200 Nether Street, N3 1JD

Section 73 Application - Removal/Variation of a condition

Supporting Planning Statement

Proposal to amend Condition 01 following grant of permission of application 22/4659/FUL

PROPOSED SOUTH WEST ELEVATION

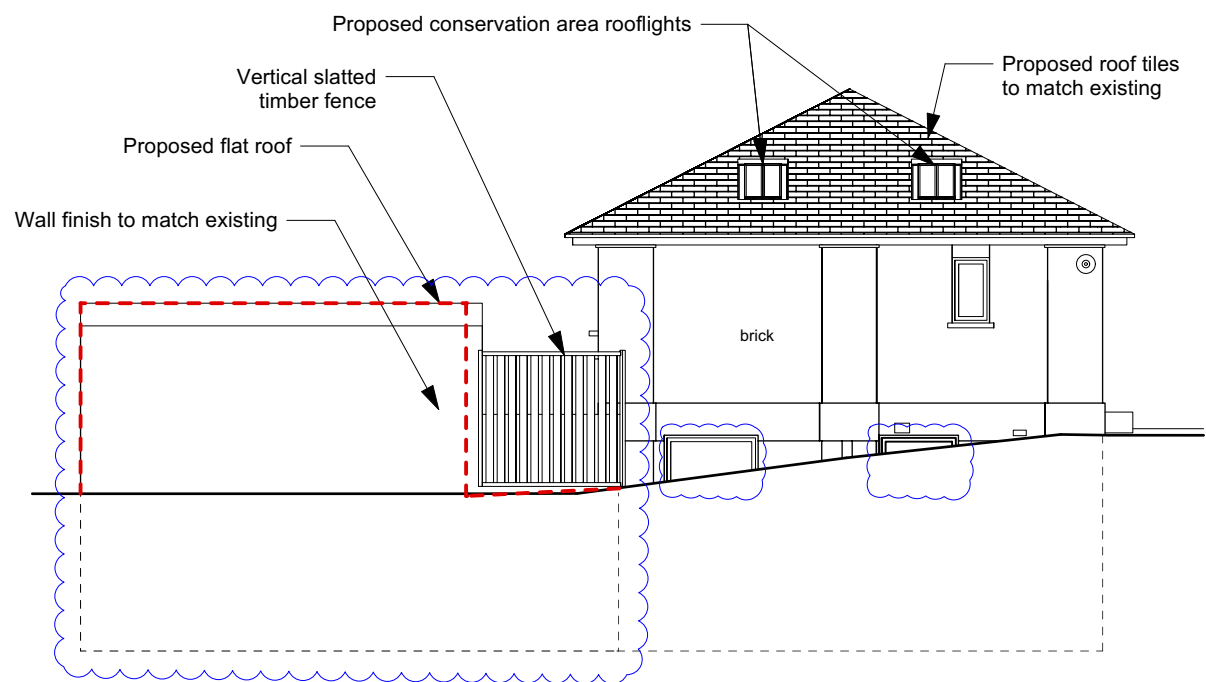
- 2. Proposal of two high level windows to the basement corridor space.**

This proposal seeks to reintroduce this window as well as an additional window on the same elevation to provide increased daylight into the basement corridor space via the small existing lightwell.

This proposed variation would be beneficial to the scheme and will improve the natural lighting condition of the basement corridor space without creating any adverse impact on the elevational treatment as there already exists an opening on this elevation and is at the lower level.

Drawing No: **F618-A-301** Rev: **A**

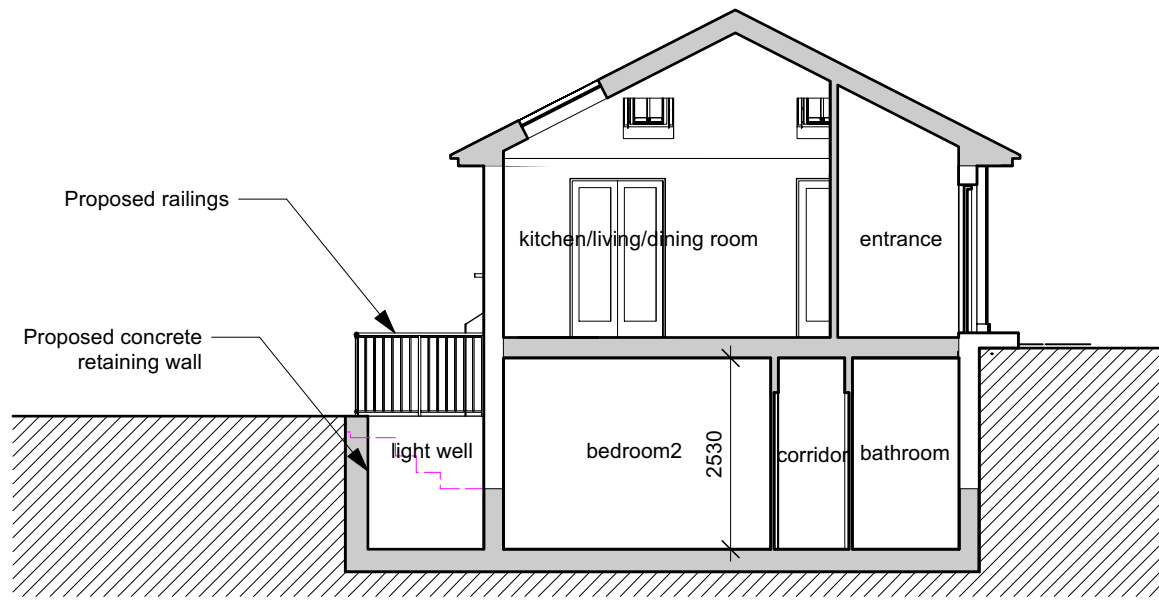
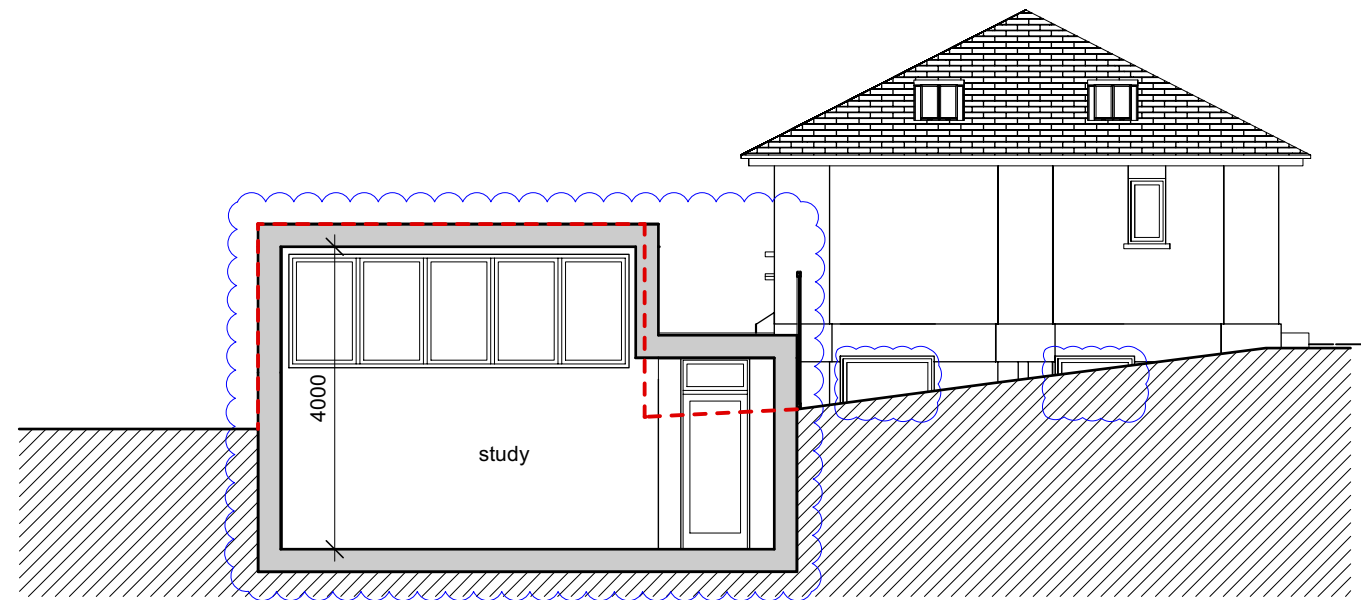
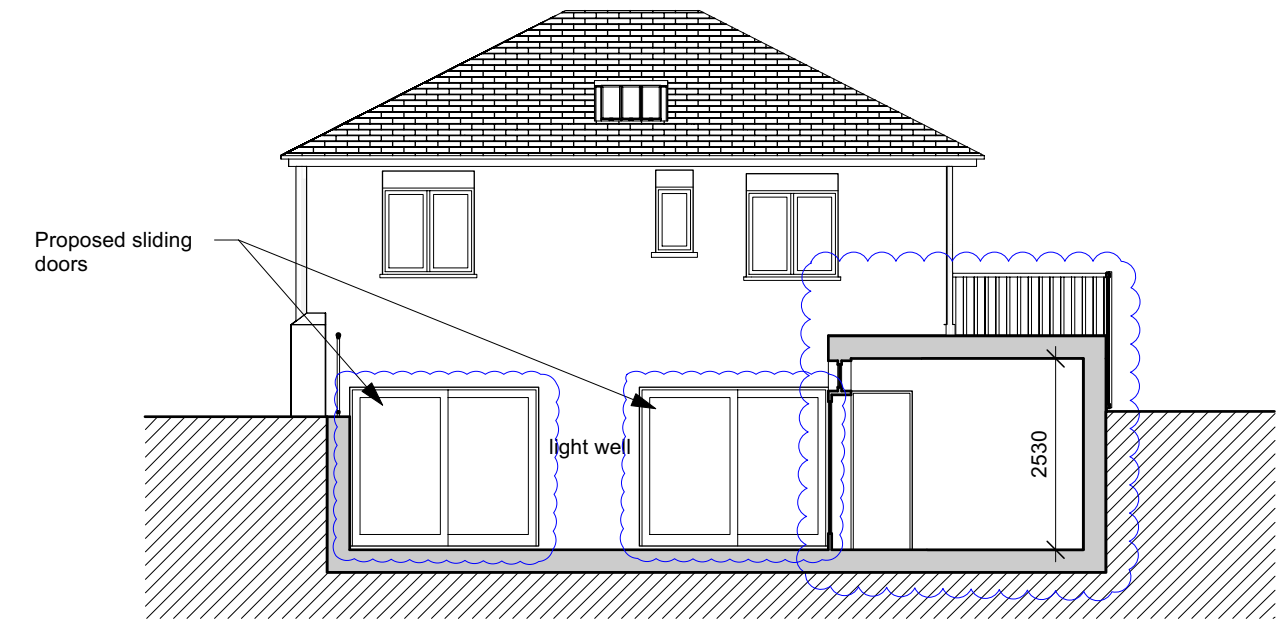
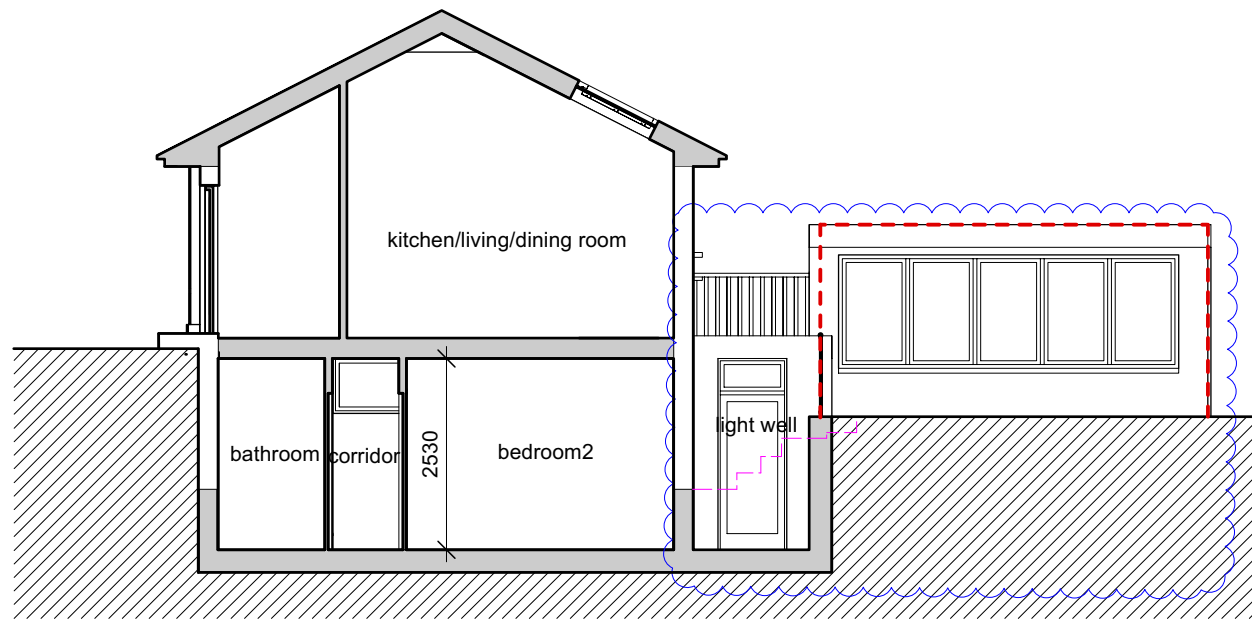
- 3. Proposal to raise the roof/ceiling height of the extension (study in the basement) to match the existing height of the garage/outbuilding (to be demolished).**

Only part of the extension is raised to the new height (not exceeding the existing) in order to ensure that this new part of the building remains, visually, as a separate entity from the retained exterior of the main house.

As the existing garage will be demolished to be replaced by the new extension, it is reasonable that the proposal's height matches the existing height.

The current proposal that has been approved would require additional boundary treatment to prevent public trespassing across the roof from Lover's Walk due to its lower height. Therefore, this proposed variation would inherently provide the necessary boundary wall to prevent trespassing. An additional section of boundary fencing is proposed to prevent trespassing over the lower portion of the extension.

Drawing No: **F618-A-105**

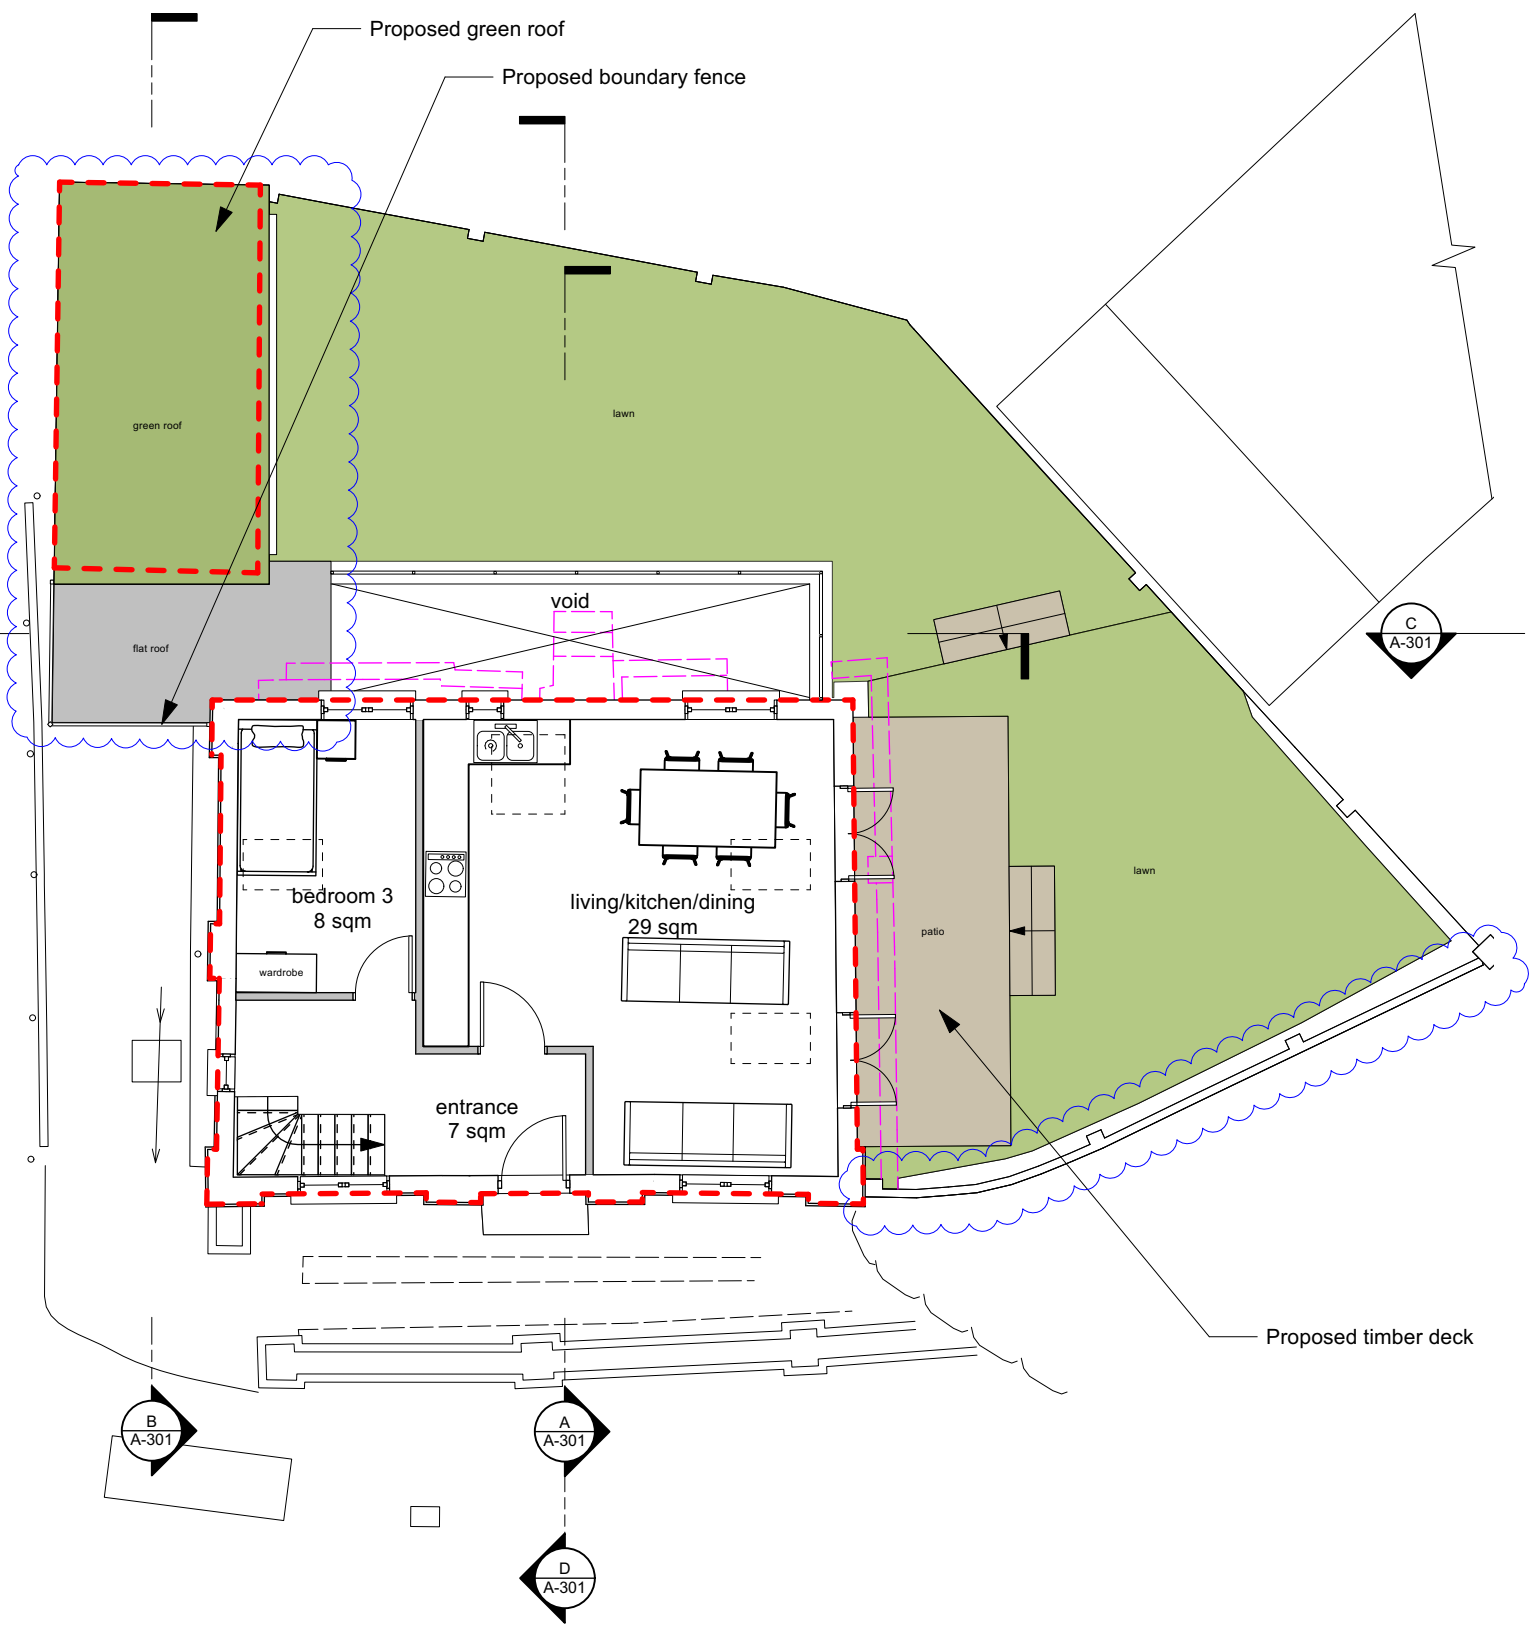
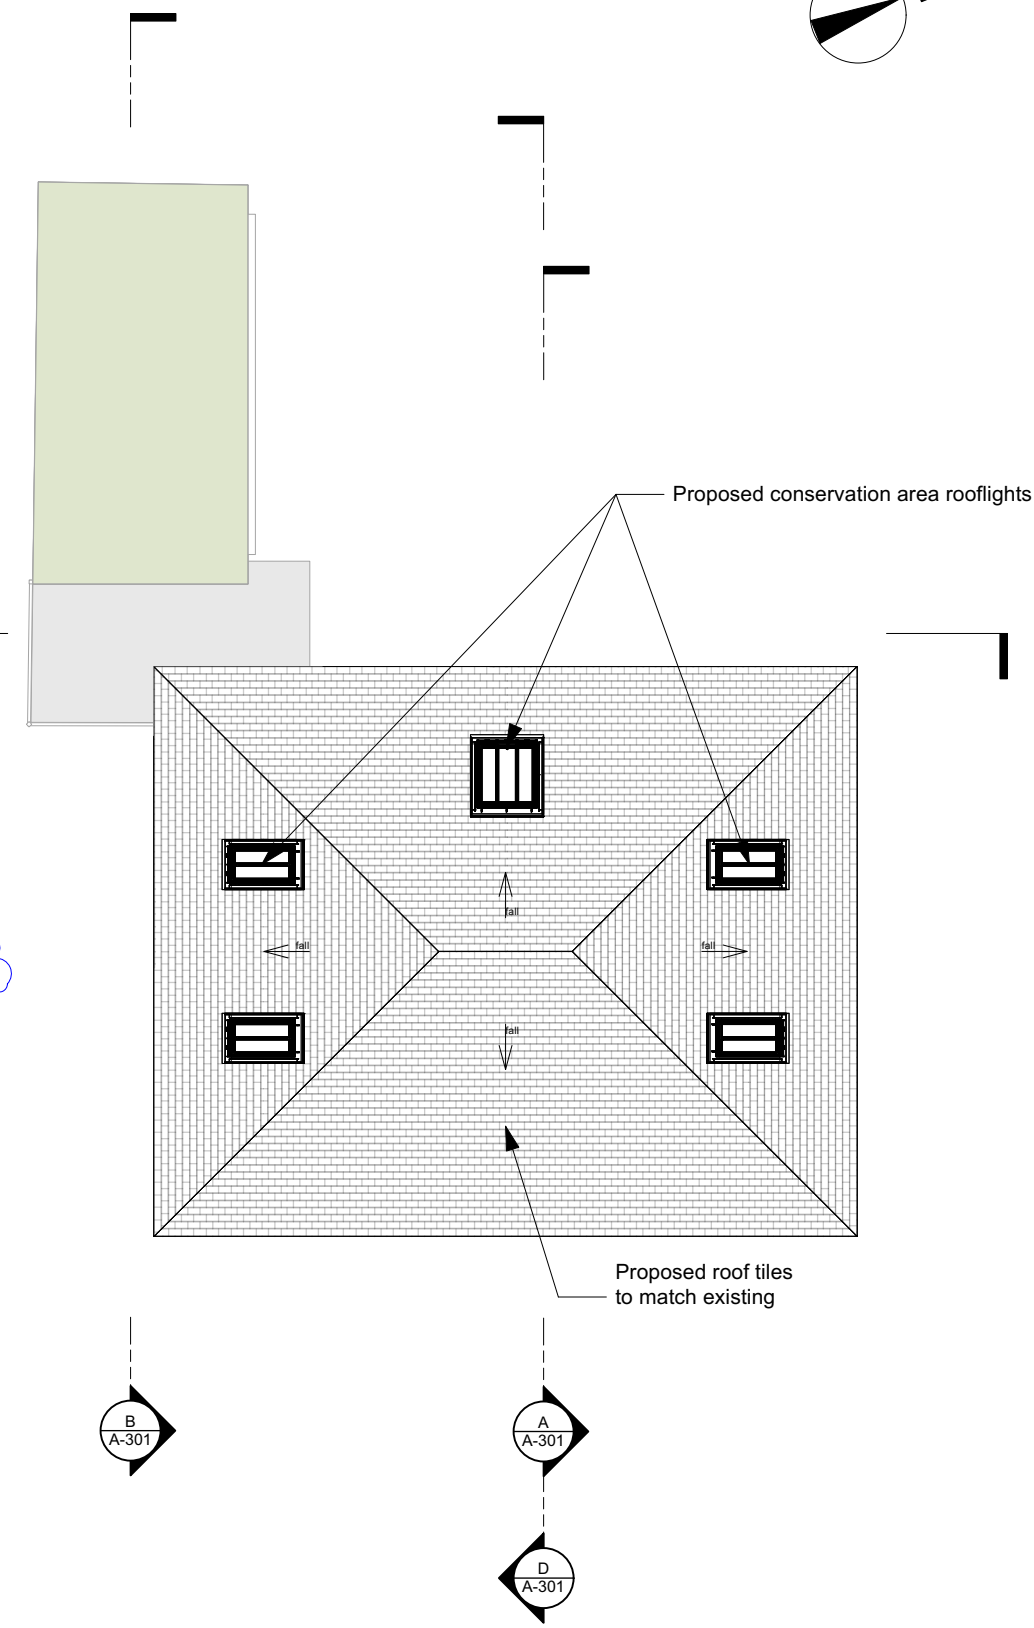
- 1. Change from the two windows of the two bedrooms in the basement to two sliding doors leading out into the light well.**

- 4. Retainment of the existing boundary wall to the front of the site.**

The proposed sliding doors with its maximised glazing will provide increased daylight into the basement bedrooms through the lightwell compared to the windows previously proposed.

The ability to access the lightwell space directly from the bedrooms is beneficial and improves the quality of the living condition for the bedrooms.

No adverse impact will be introduced with this change in comparison with the original proposal as the affected elevation is to the rear of the dwelling and sunken in nature. (The original proposal to finish the lower section of the exterior wall here with brick has also been omitted in this application and a railing is introduced around the perimeter of the light well to prevent falling).

The existing brick wall to the front of the site is proposed to be retained in order to act as tree protection measures during construction.

EXISTING SOUTH WEST ELEVATION

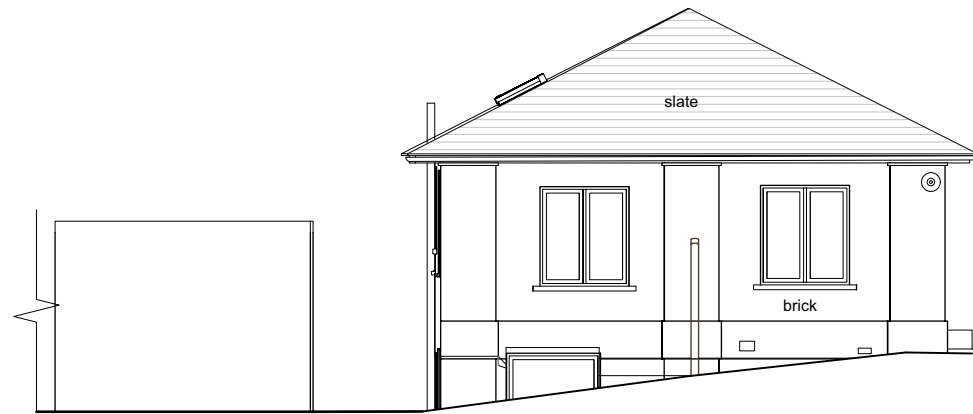
As shown in the updated existing basement floor plan and elevation, there is already an existing window on the Southwest elevation.
